From: Liz Rogers [REDACTED]
Sent: 15 August 2018 14:44
To: Planning.Responses
Subject: RE: Planning Consultation on: BE/77/18/PL

App No: BE/77/18/PL

Address: Land West of New barn Lane, Bersted

Proposal: Erection of 10 No. dwellings and associated works

scheme: Land West of New Barn
Lane, North Bersted
client: Linden Homes
drawing: Tree Protection Plan
date: 25.06.2018
scale: 1:500@A0
dwg no: LIN21936-04(10 unit scheme)
drawn: TRG checked: MW

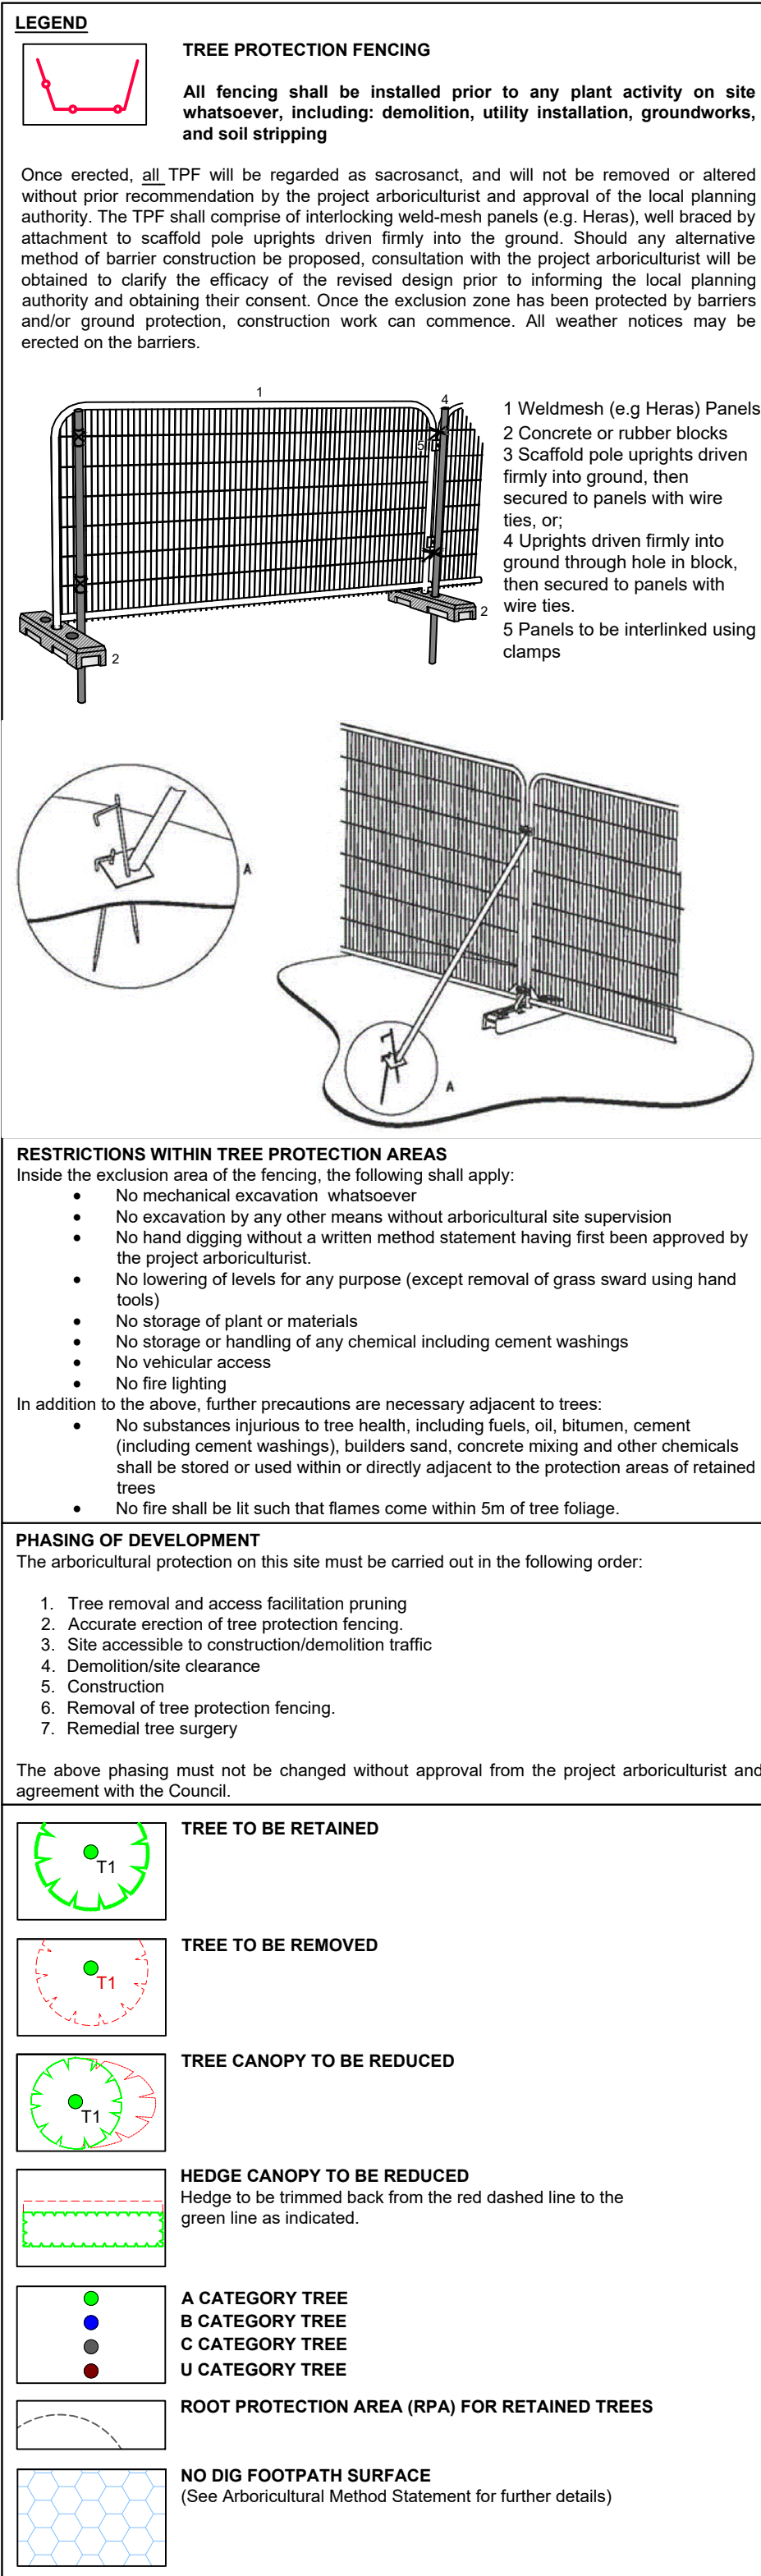
The hedgerows on site are used by bats for commuting and foraging and will need to be retained and enhanced for bats. This will include having a buffer strip around the hedgerows and during construction fencing should be used to ensure this area is undisturbed. Any gaps should also be filled in using native hedge species to improve connectivity. Where any hedge is to be removed at detailed within the survey, new hedgerow should be planted. Conditions should be used to ensure this.

client: Linden Homes
drawing: Landscape Proposals
date: June 2018
scale: 1:200@A1
drawing no: LIN21257 12DR
drawn: DC checked: AE

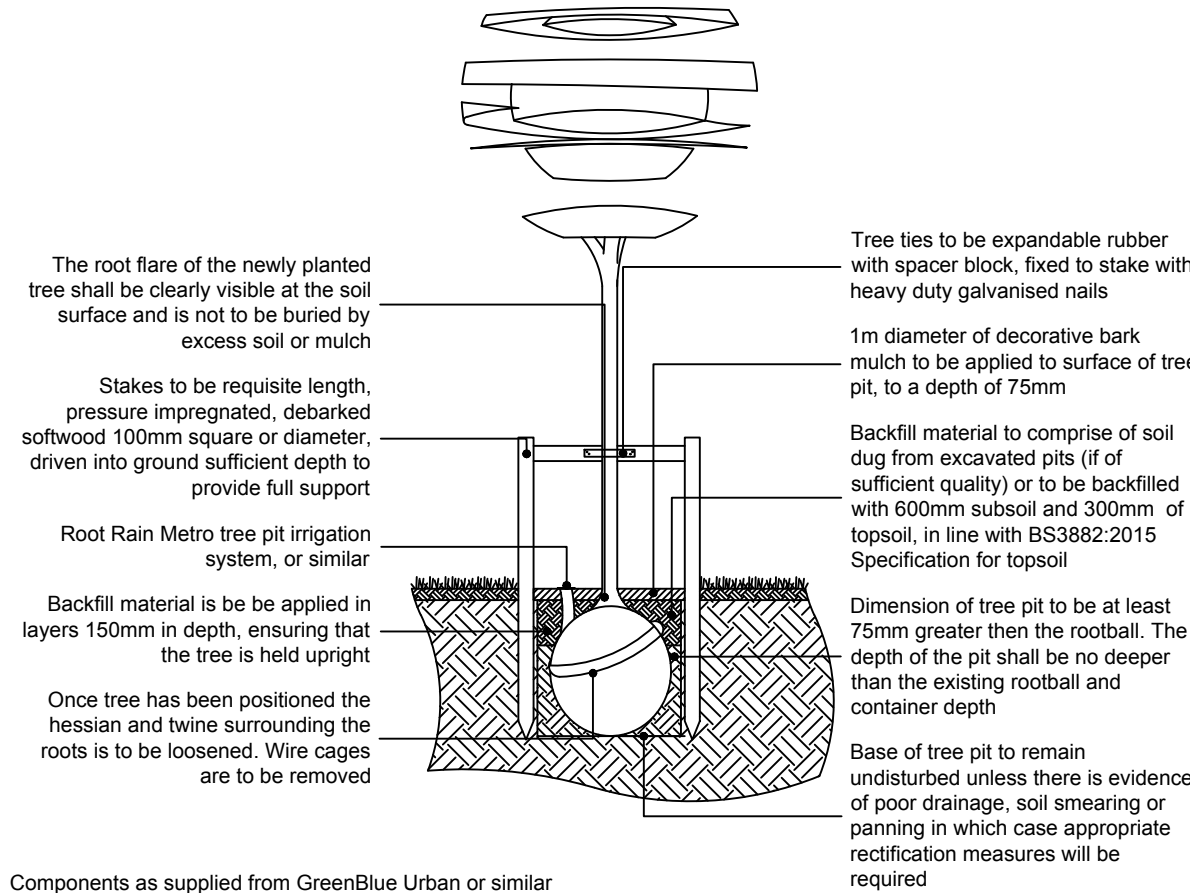
- Any trees removed should be replace at a ratio of 2:1
- Wildlife pond
- Wildflower meadow

- Filling any gaps in tree lines or hedgerows with native species
- Bat and bird boxes installed on the site
- Grassland areas managed to benefit reptiles.
- Log piles onsite
